Modification Application SSI-7485-Mod-2

This submission by Leichhardt Against WestConnex (**LAW**) responds to the proposed modification to M4-M5 Link, Mod 2 - *The Crescent overpass and changes to pedestrian infrastructure in North Annandale, Rozelle and Rozelle Bay Foreshore area (the Modification)*.

Figure 4-2 The Crescent/Johnston Street/Chapman Road layout in EIS and proposed modification model

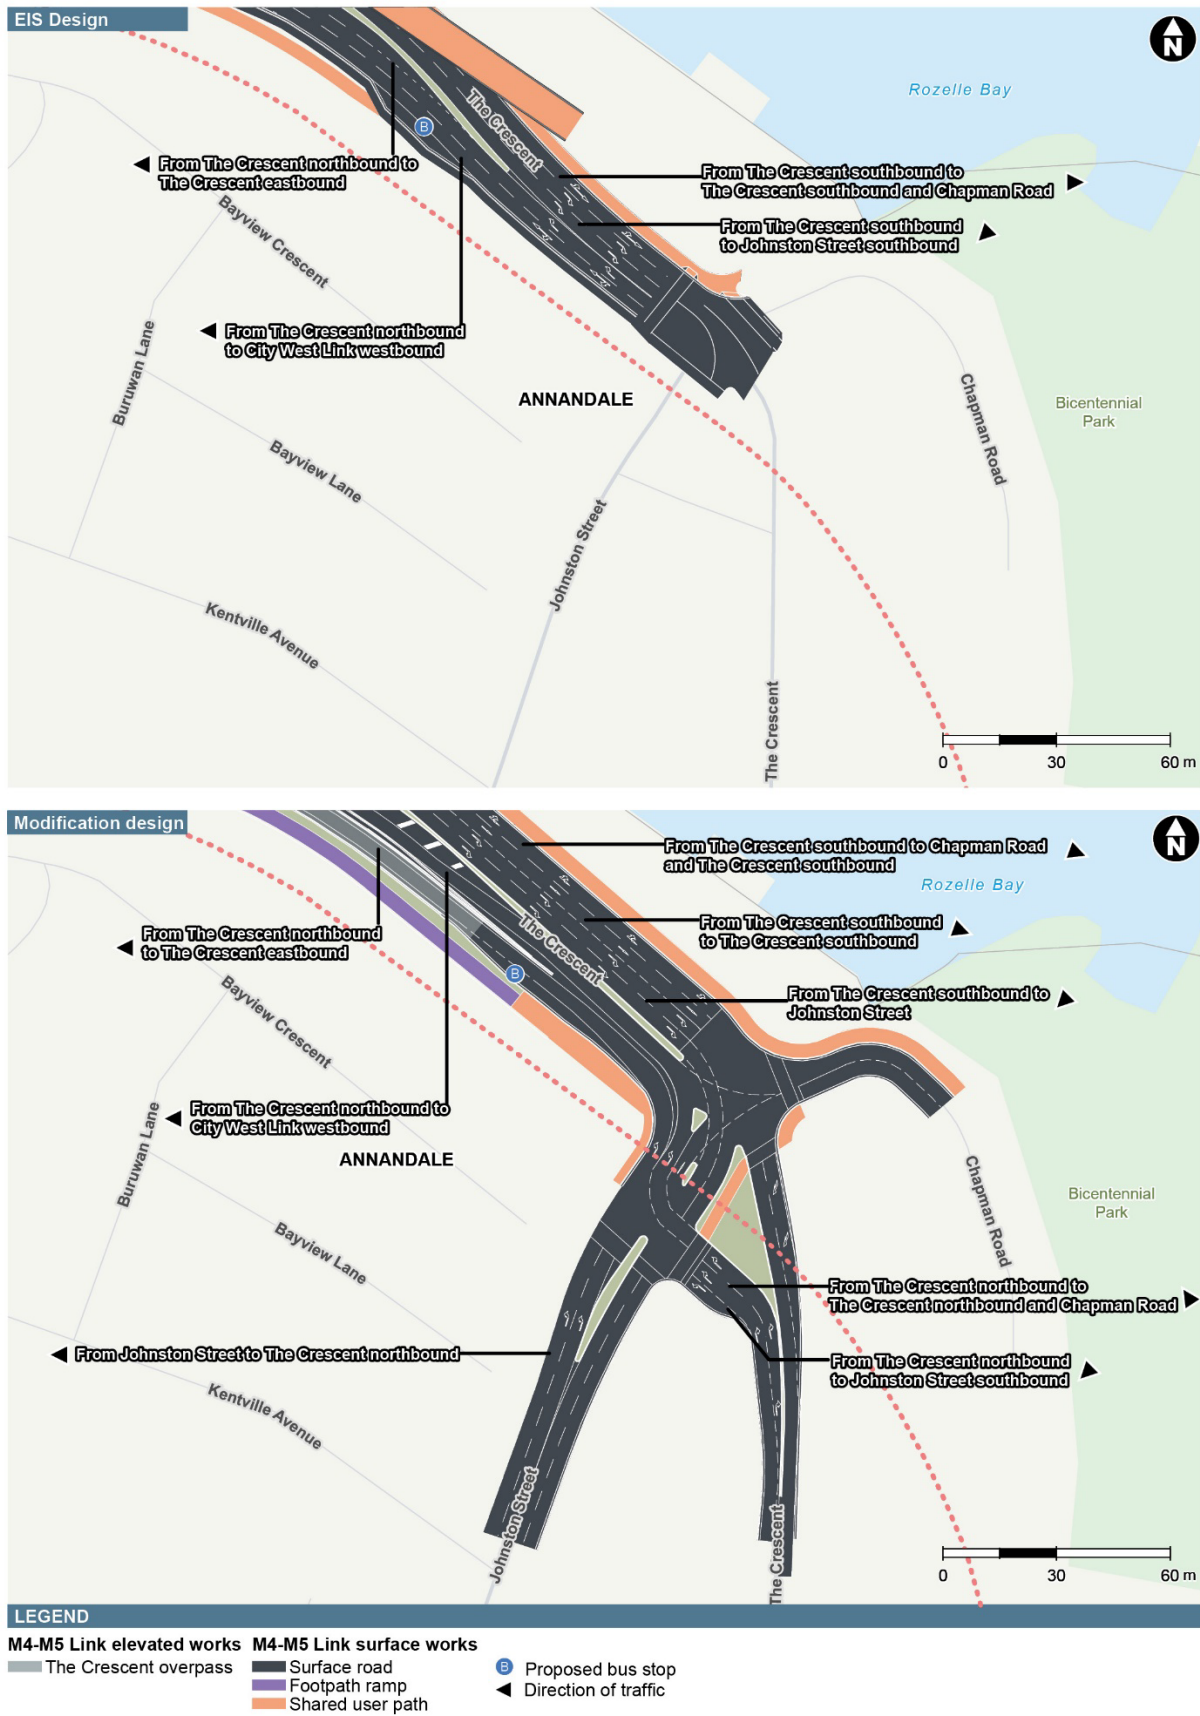
This intersection is one of the main access points to the foreshore parks and to the Tramsheds and local pedestrians are again being inconvenienced with more circuitous crossings at road level and the ridiculous foot bridge going in the wrong direction the long way round. RMS should be ensuring easy access for walkers, families, the elderly and people with a disability to our open spaces, not inserting major motorway feeder roads in the way. There should be pedestrian crossings over the Crescent both at the northern side of Johnston St and the southern side.

*"Pedestrians currently accessing Bicentennial Park from Johnston Street would be required to use the new signalised pedestrian crossing, **which would not provide as direct an access to Bicentennial Park**. The total number of traffic lanes crossed on The Crescent would be the same as presented in the EIS (five lanes), **but moving it to the eastern side, would split the crossing into two sections** – one crossing of three lanes and one crossing of two lanes."*

Planning should not approve the new pedestrian crossing arrangement, but should require RMS go back to the drawing board and find a way to preserve access to the foreshore parks from Johnston Street which does not require multiple crossings. This is a high pedestrian area, please prioritise pedestrians not cars.

The Modification involves removing the right-hand turn into the Crescent from Johnston Street, stating that 'the number of traffic movements are limited and alternative traffic routes are available'. We are not sure as to the basis for stating that such movements are 'limited'; the reality is that the local traffic from Annandale will be severely impacted by this change, which makes it difficult for them to access the eastern section of the Crescent towards Forest Lodge. The reference to 'alternative routes' is also not further explained. The only option for such traffic that can no longer turn right into the Crescent is to access via local streets. This is an unacceptable impacts on the road system which should not be permitted. The Government should be directed to redesign this intersection so as to maintain access via the local road network to the Crescent.

Many residents appear unaware of the new no right turn from Johnston St into the Crescent proposed in this Modification. This is a high impact change yet has not been highlighted as such in the Modification. The no right turn into the Crescent is egregious and will cause rat running throughout Annandale. It is unacceptable for RMS to stop local drivers accessing the Crescent at that point. Why should our local trips across our district be made less convenient by this project and why should the residents of the streets that will become the new rat runs have to lose their amenity so that toll road traffic can be induced into Johnston St? At the Community Reference Working Group, LAW was told by the JV that local traffic was expected to use the City West Link to access the Tramsheds instead! But this is the same City West Link that will be grid locked as a result of the extra traffic from the M4 East for the next 5 years and after that from traffic coming out of and going into the tunnels. This Project is supposed to reduce congestion but this no-right turn will only increase it.

LAW objects to the no right turn and calls on Planning to require RMS to look again at how to make this intersection fair for all road users, both local traffic and toll road customers.

Figure 4-10 Rozelle Interchange: average travel time for buses – comparison between AM peak hour 'with project' EIS and 'with project' modification scenarios

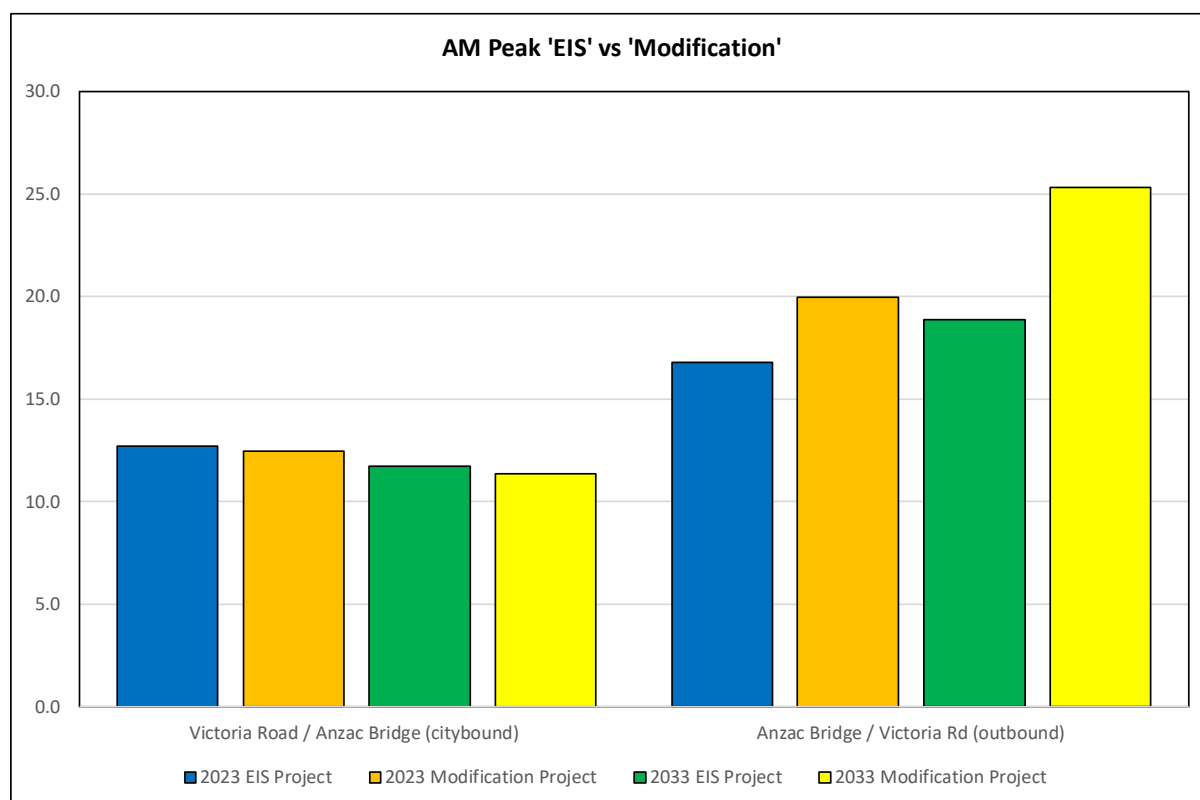
The Modification will also increase queues on Victoria Road leading to longer bus journeys to Druitt St. As shown in Fig 4-10 Appendix B: *Traffic and transport assessment*:

“In the outbound direction in the AM peak, bus travel time is forecast to increase for the same reasons that affect the general traffic travel times i.e. the additional traffic on Victoria Road northbound, as discussed in section 4.1.5. The increased traffic volumes on Victoria Road means that the queue caused by the capacity constraint to the northern end of Victoria Road in Drummoyne is longer and takes longer to dissipate. In 2023, bus travel times are forecast to increase from about 17 minutes to about 20 minutes, while in 2033, bus travel times are forecast to increase from about 19 minutes to about 25 minutes.”

Planning should **not** approve a Modification that increases travel times for public transport users.

LAW objects to the Modification on the grounds of the increased travel times for citybound buses.

Figure 5-1 Total traffic emissions comparison area coverage

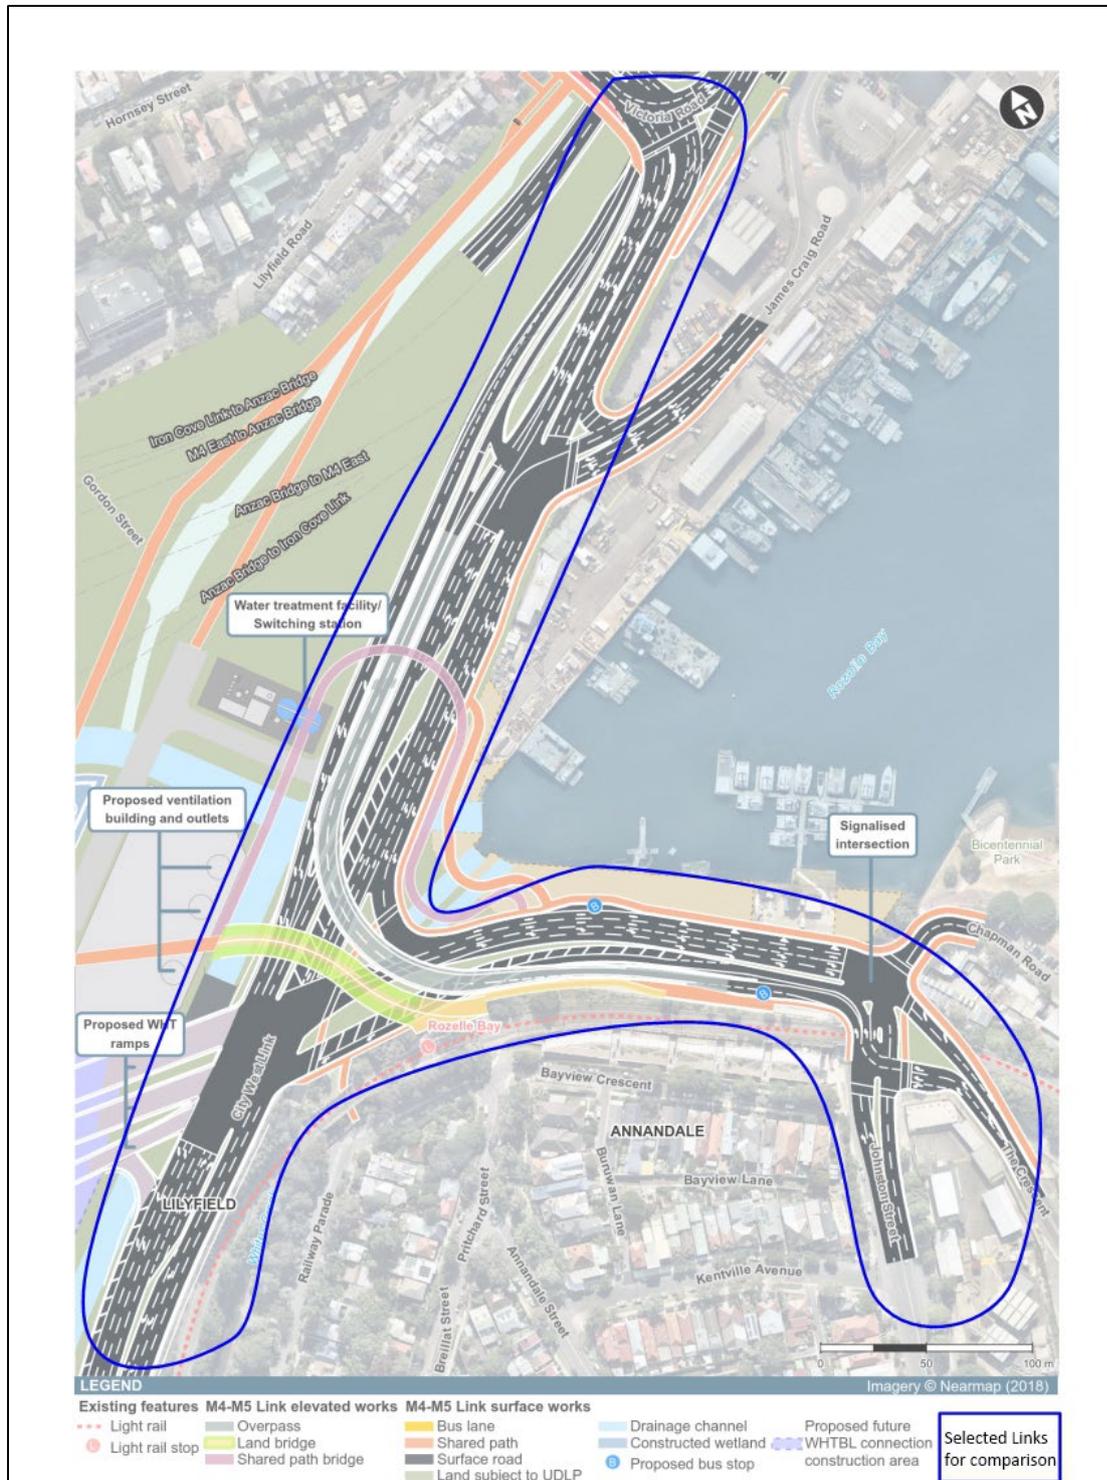
Table 5-1 of Appendix D *Air quality assessment* shows the Total traffic emissions in the vicinity of the proposed project Modification. The data discloses that total emissions of NO_x will be 50% higher at 54.5 tonnes per year in 2033 with the Modification (compared to 36 tonnes per year without the modification.

LAW objects to the Modification on the basis that it will make air quality worse in the vicinity and therefore should be rejected on those grounds.

Table 5-2 shows that by 2033 absolute changes in total traffic emissions of NO_x in the vicinity will reduce by 40.47% without the Modification and only 22.04% with the Modification.

Again the Modification will lead to worse air quality so should not be approved.
